Our ref: Q080666 el/jn
Your ref: 20/00293/OUT
Email: emma.lancaster@quod.com
Date: 17 June 2020

Application Ref: 20/00293/OUT – Bicester Gateway Phase 1B

Enc Highways Technical Note
Cc Albion Land

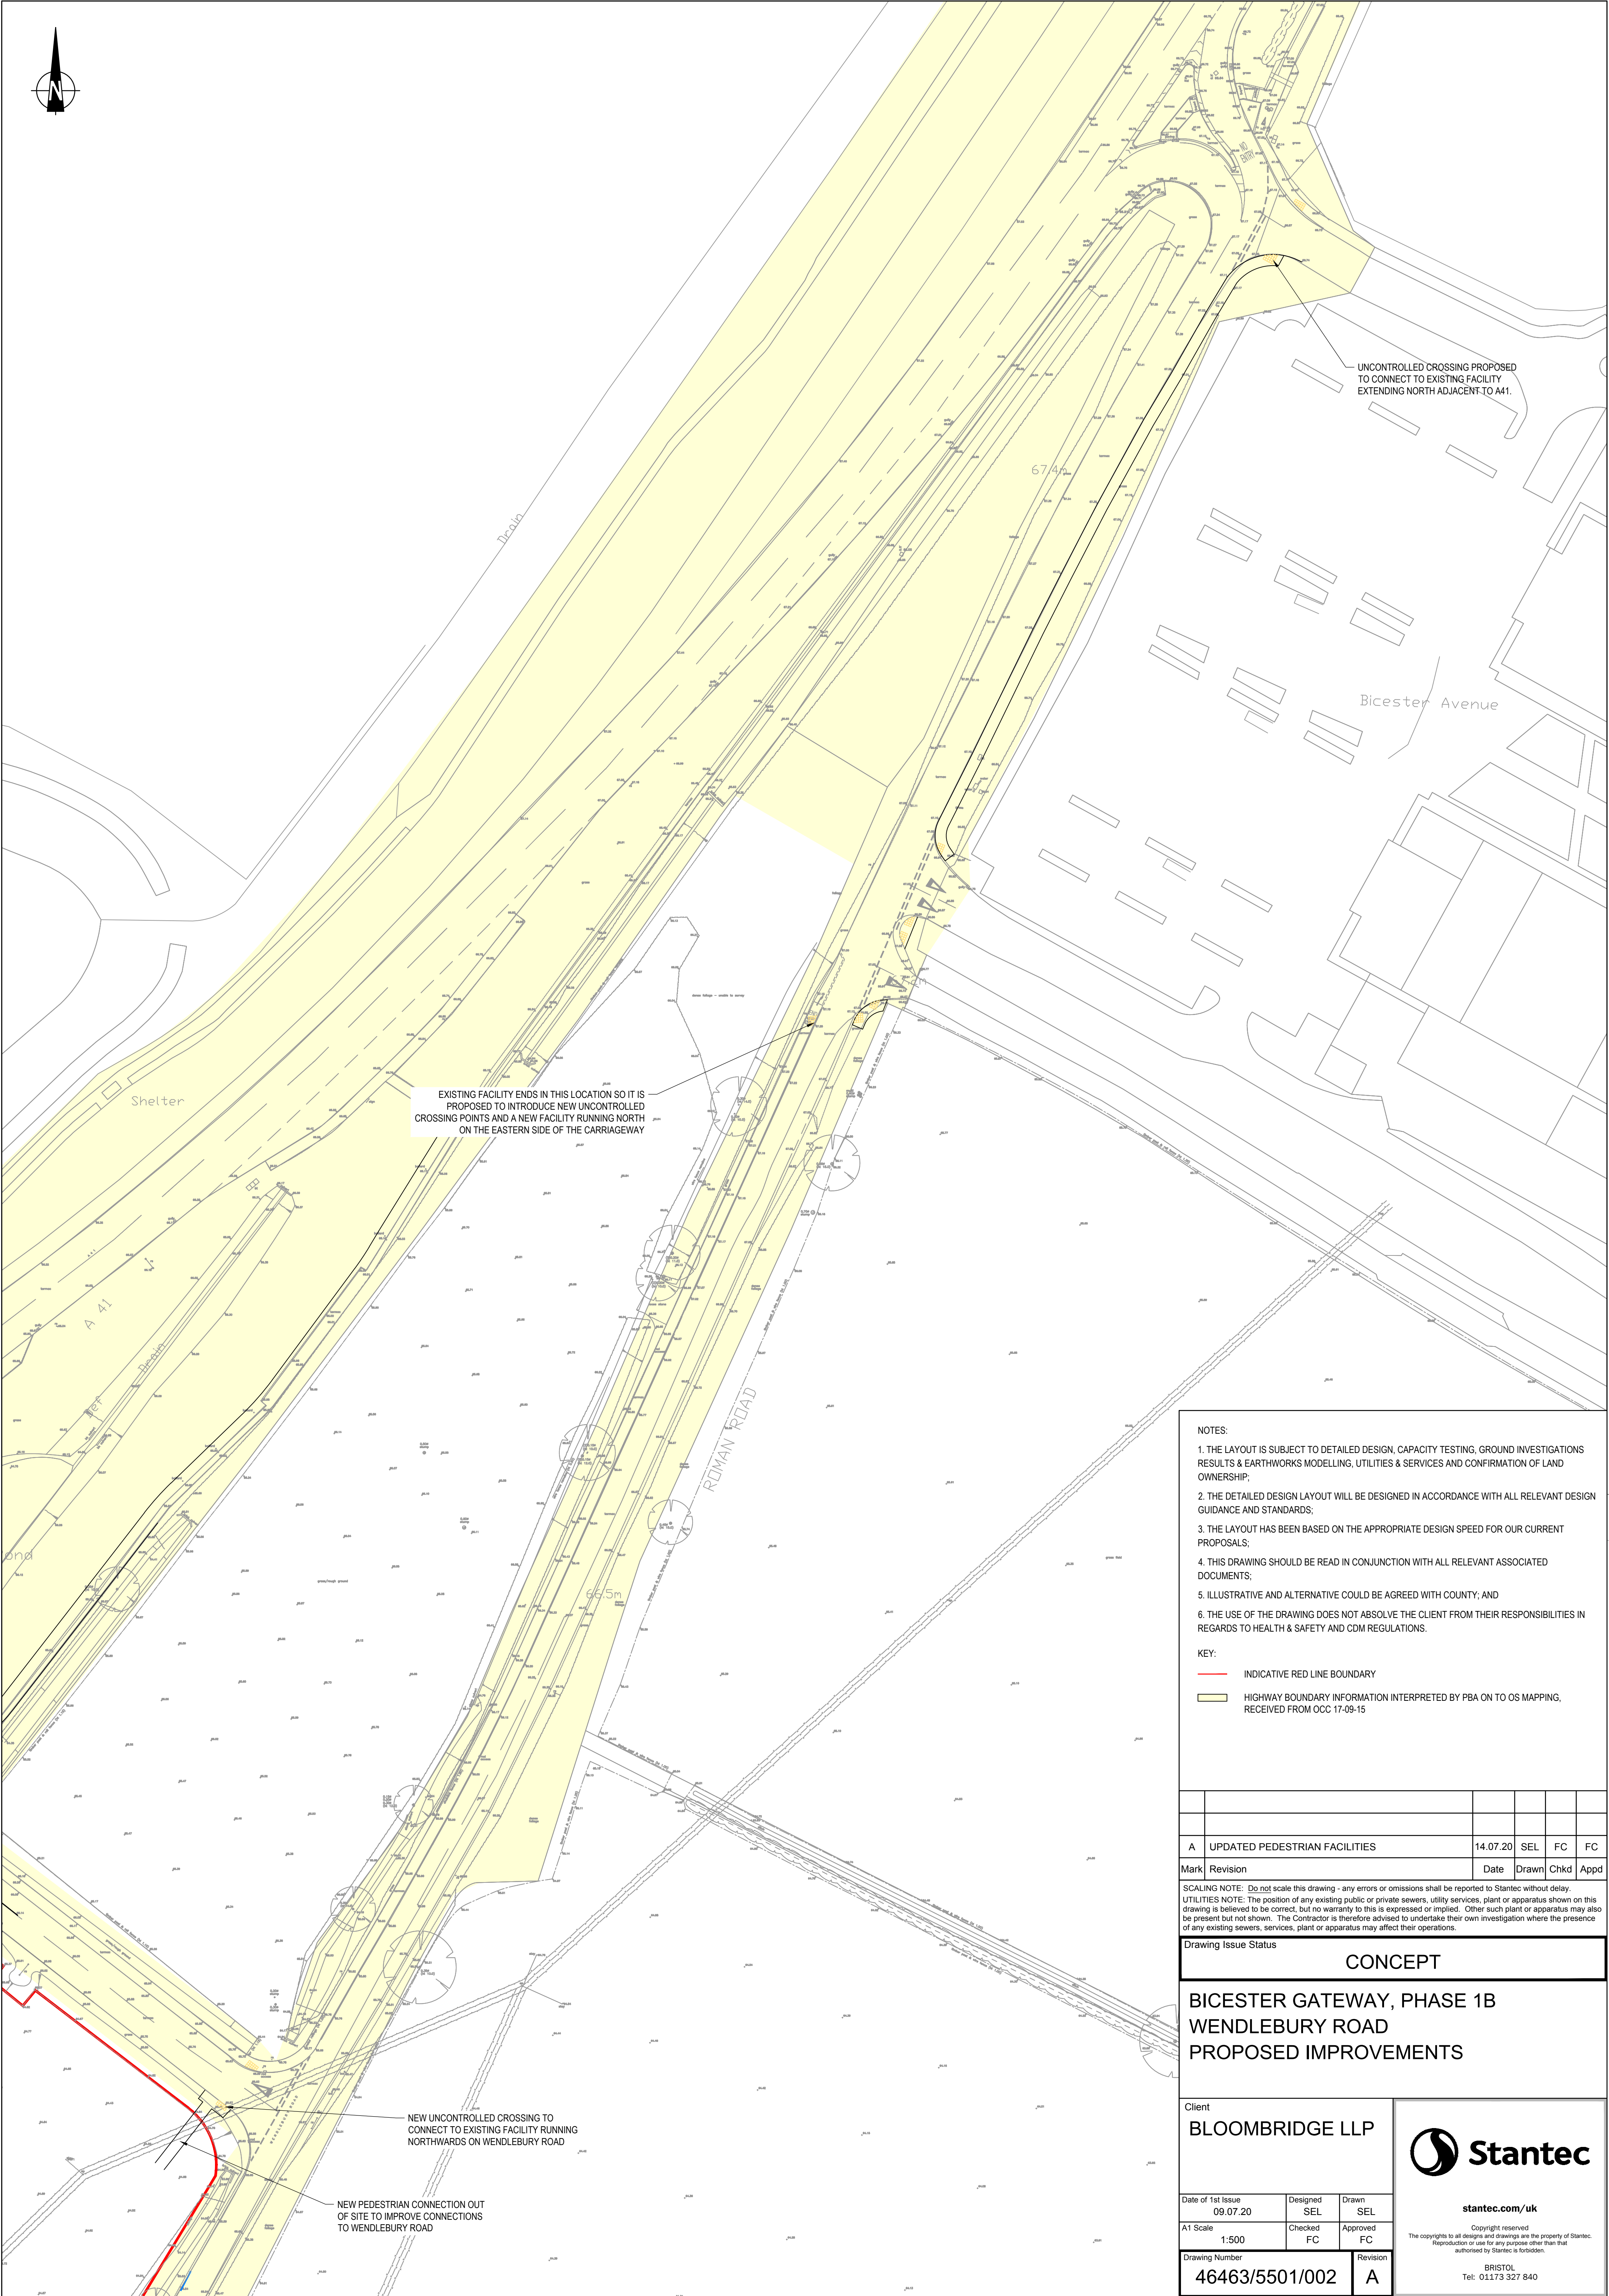
13. The existing crossing on Charles Shouler Way cannot support any intensification of use. The existing carriageway is too wide at circa 12m, lacks a refuge and provides limited pedestrian/cyclist – driver intervisibility. It is both unattractive to users and unsafe. The proposed development would intensify use of the crossing. Whilst the applicant has not quantified the existing use of the path it is likely to be negligible. Whether the site was developed for employment or mixed use some improvements would be required. Whilst there is an outline consent for employment on the site, access was not determined and in any event the proposed mix would be expected to generate significantly more demand by pedestrians and cyclists (including public transport users) at all times of day, days of the week and all ages and abilities.

14. The current proposals seek to respond to this by providing a narrow sub-standard refuge, contrary to DMRB CD143, CD195 and OCC design guidance. It will therefore remain an unattractive route to users and fails to maximise the opportunity for healthy travel choices.

18. The cycling design vehicle for cycle crossings as set out in CD195 is 2.8m long and 1.2m wide (red boxes on **Figure 1** above). This is reflected in the design of the refuges at the Phase 2 site access roundabout which are 3.0m long and 3.0m wide where two-way cycle movements can therefore be fully accommodated.

19. In contrast the proposed Phase 1B refuge at 2.0m is insufficiently long to accommodate the cycling design vehicle.
20. The visibility requirements for a cycle crossing as per CD195 para E/3.5 are based on a desirable minimum setback of 4.5m and an absolute minimum setback of 2.4m. The Y distance whilst in DMRB terms would relate to CD123 in practice it would be more typical to adopt MfS2 parameters. Whilst the link is derestricted it is likely that speeds will be constrained to 60kph i.e. a Y distance of 59m. These splays must be secured free from obstruction (including rearrangement of headwall fencing).

21. The introduction of the splitter island is contrary to CD116 introducing sub-standard geometry. This compromises highway capacity and safety of the A41-Vendee Drive roundabout.

24. It is proposed to reduce the westbound lane width from 3.65m to circa 2.9m as a result of the extension of the central splitter island. There is no justification for narrow lanes which will be detrimental to safety and likely to result in damage to infrastructure, damage to vehicles particularly HGV and to buses and over-running of the pedestrian crossings. This could be addressed by commensurate widening of Charles Shouler Way so that a minimum lane width of 3.65m is maintained (whilst ensuring that entry path curvature is maintained).
